City of Portland, Maine - Building or Use Permit Application
 389 Congress Street, 04101 Tel: (207) 874-8703, Fax: (207) 874-8716

Permit No: 10-0081	Issue Date:	CBL: 040 C022001
------------------------------	--------------------	----------------------------

Past Use: Commercial - Restaurant "El Rayo Taqueria"	Proposed Use: Commercial - Restaurant "El Rayo Taqueria" - Install 7' x 7' Vestibule around front door	Permit Fee: \$40.00	Cost of Work: \$1,450.00	CEO District: 1
		FIRE DEPT: <input type="checkbox"/> Approved <input type="checkbox"/> Denied		INSPECTION: Use Group: Type
Proposed Project Description: Install 7' x 7' Vestibule around front door		Signature:		Signature:
PEDESTRIAN ACTIVITIES DISTRICT (P.A.D.)				
Action <input type="checkbox"/> Approved <input type="checkbox"/> Approved w/Condition <input type="checkbox"/> Denied				
Signature:		Date:

Dept: Building **Status:** Approved with Conditions **Reviewer:** Jeanine Bourke **Approval Date:** 02/08/2010
Note: **Ok to Issue:**

Sheet #: 3 OF 5  
**A200**

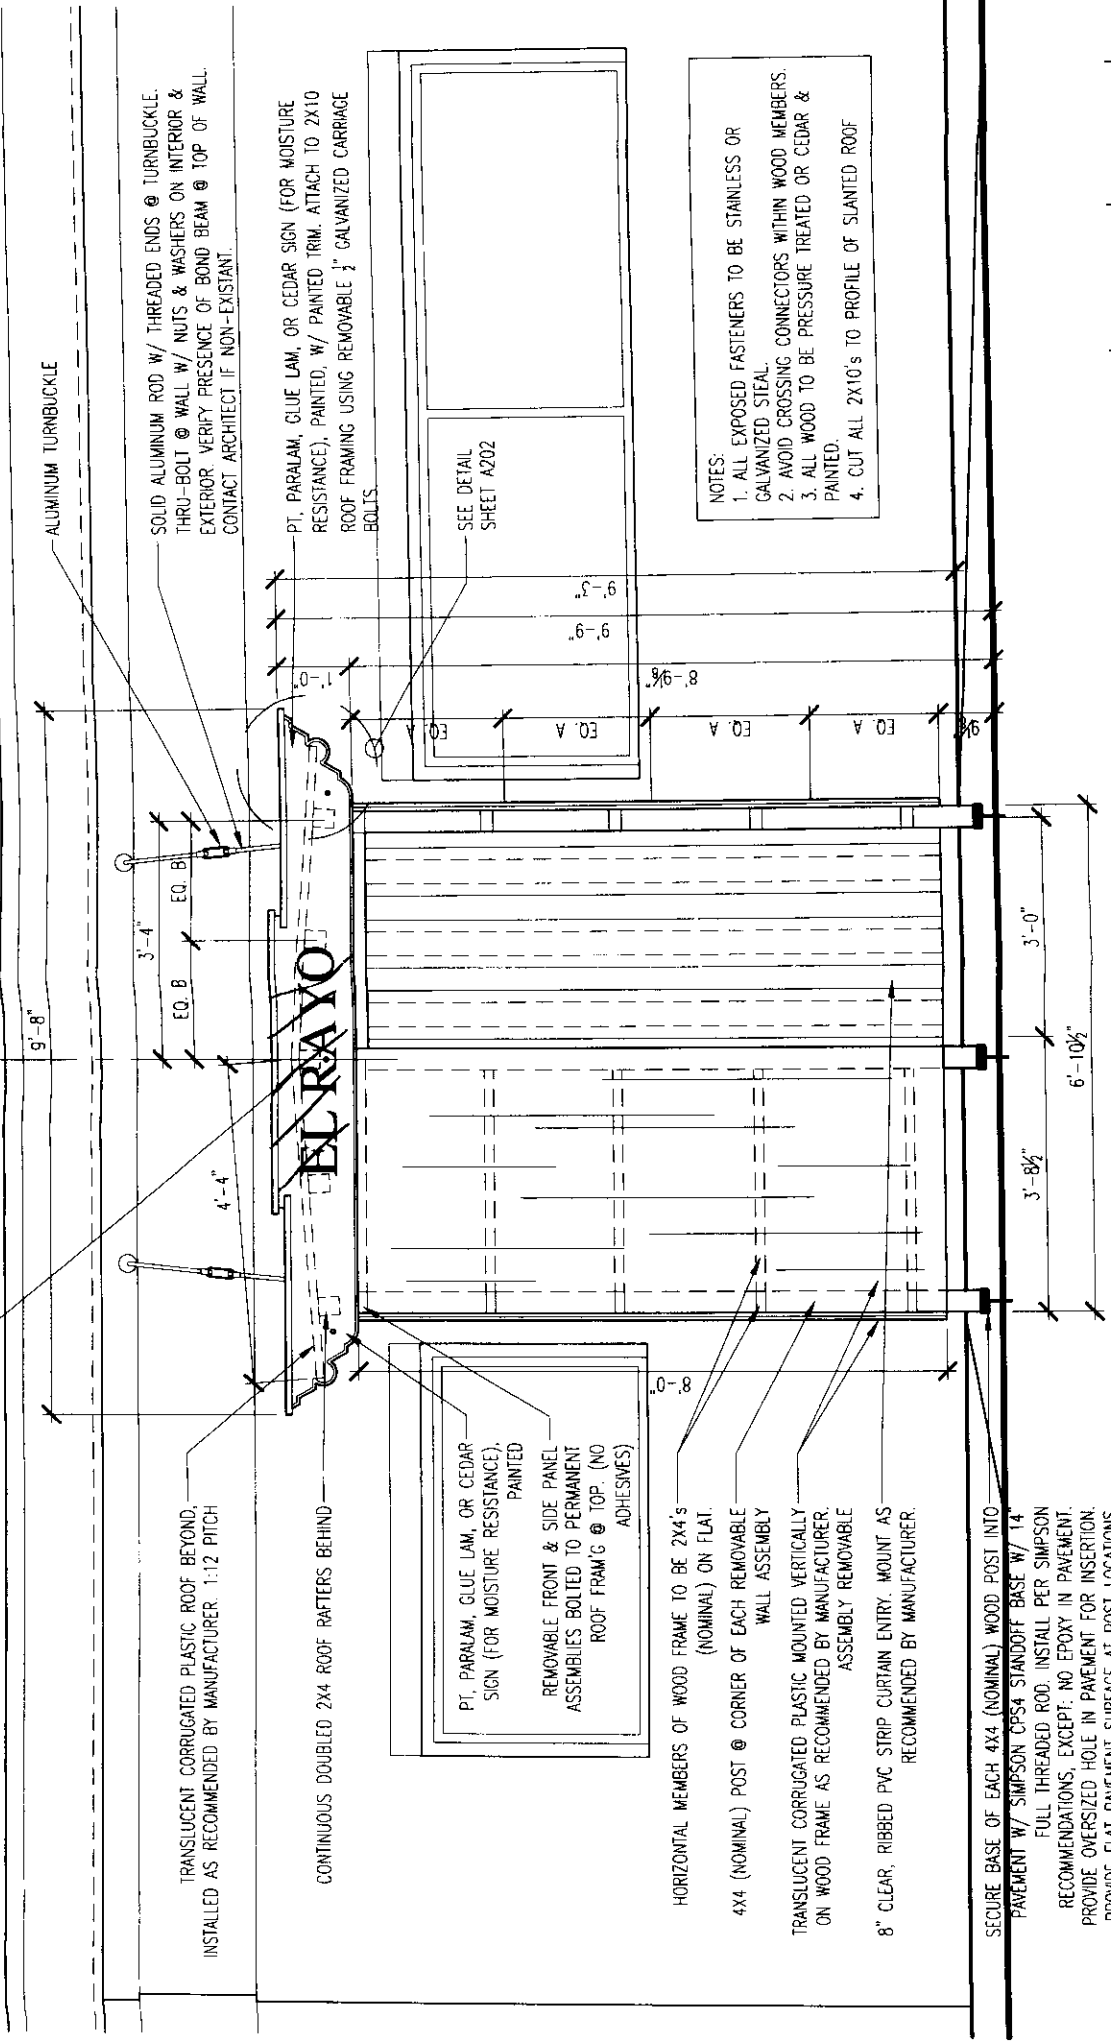
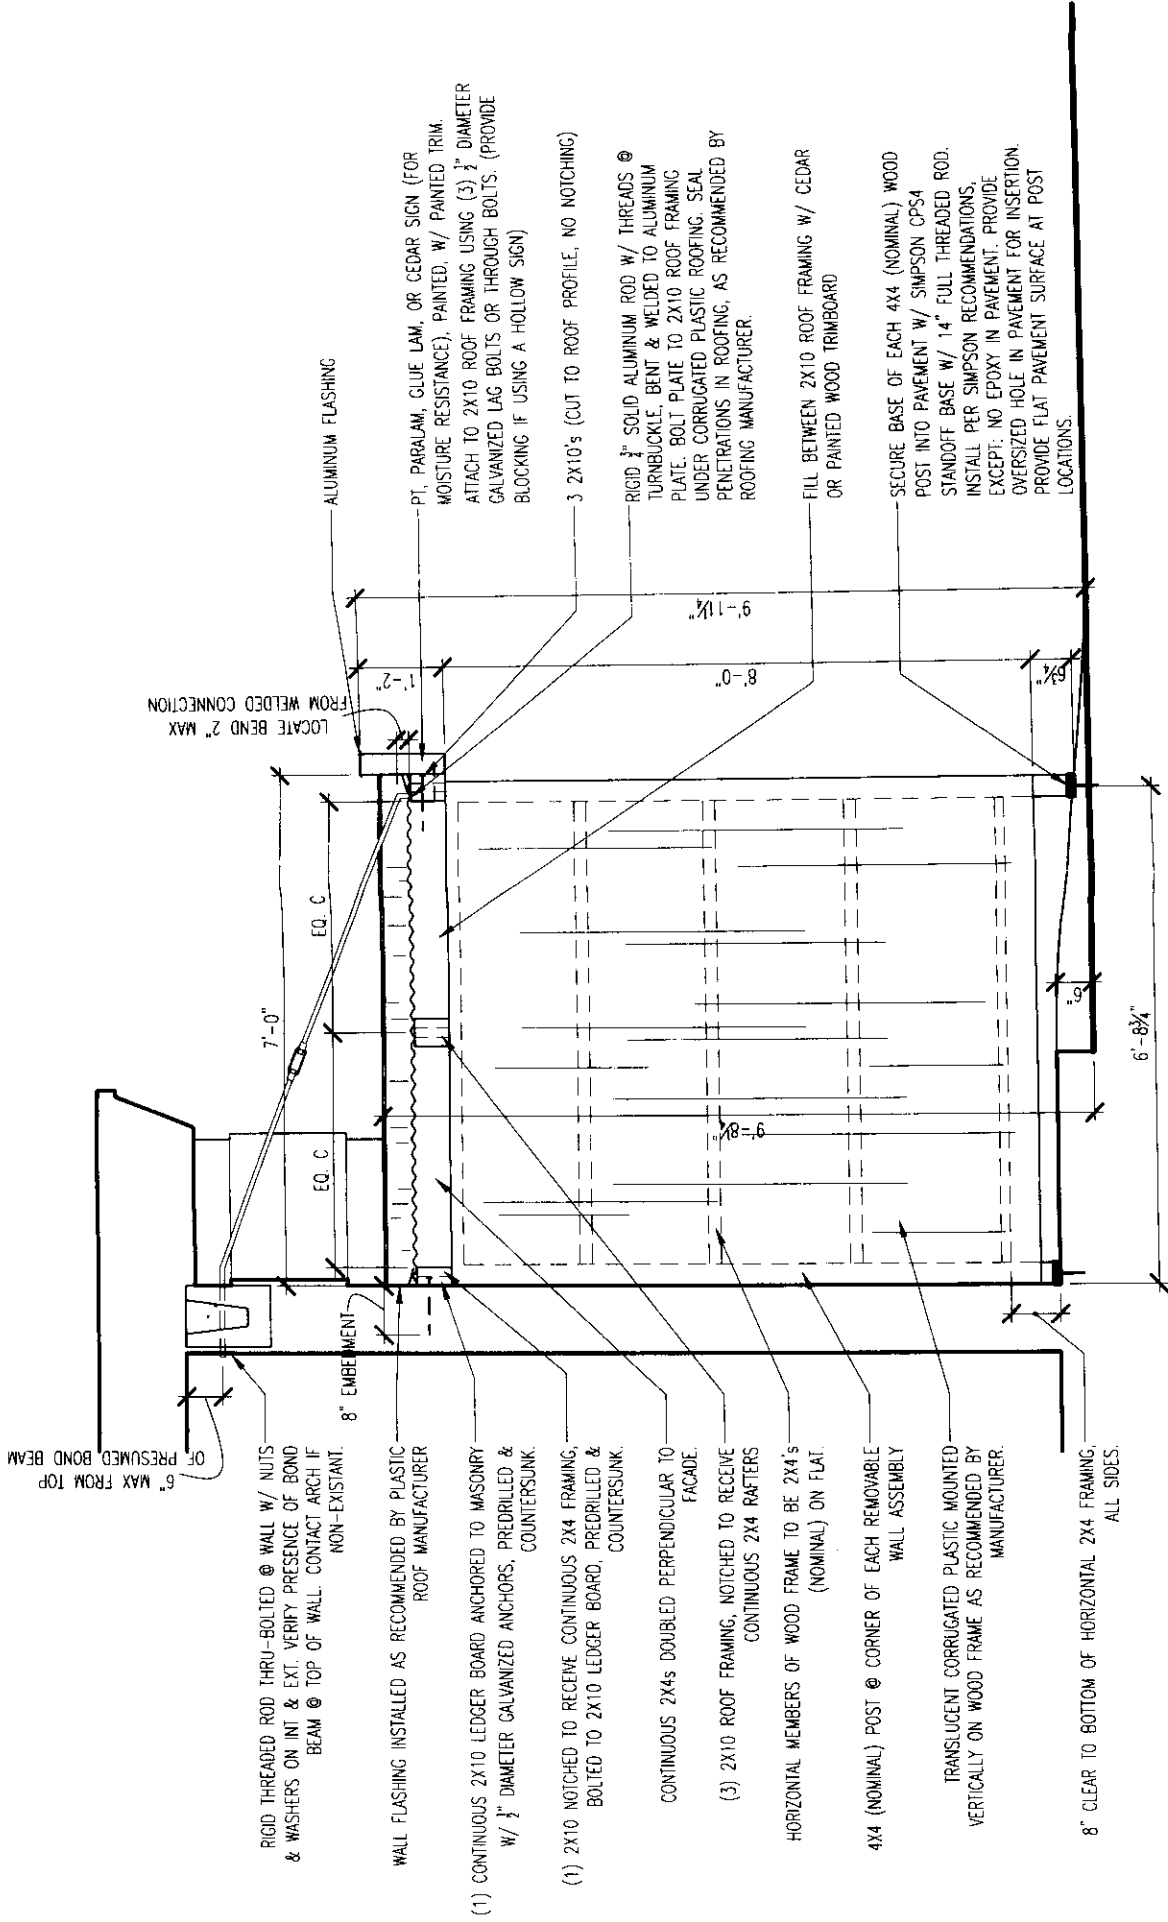
- 1) If the design of the angled rod fastening for the canopy into the bond beam is changed, a new design shall be submitted for approval.
- 2) Separate permits are required for any electrical, plumbing, sprinkler, fire alarm or HVAC or exhaust systems. Separate plans may need to be submitted for approval as a part of this process.
- 3) Application approval based upon information provided by applicant. Any deviation from approved plans requires separate review and approval prior to work.

1/28/2010-mes: Barbara B previously determined that this entry way does not need a site plan review or exemption.
2/8/2010-jmb: Left vmsg for Cynthia W. For question on the bearing of the 3-2x10 center beam for the roof structure. Cynthia left msg to call Becky B. Spoke to Becky and she clarified the roof is really like a canopy and the walls will be removable. The roof structure is fastened with brackets, non bearing on the walls. The posts have the threaded rod and standoff bracket attached and the rod will protrude into the ground by 4".
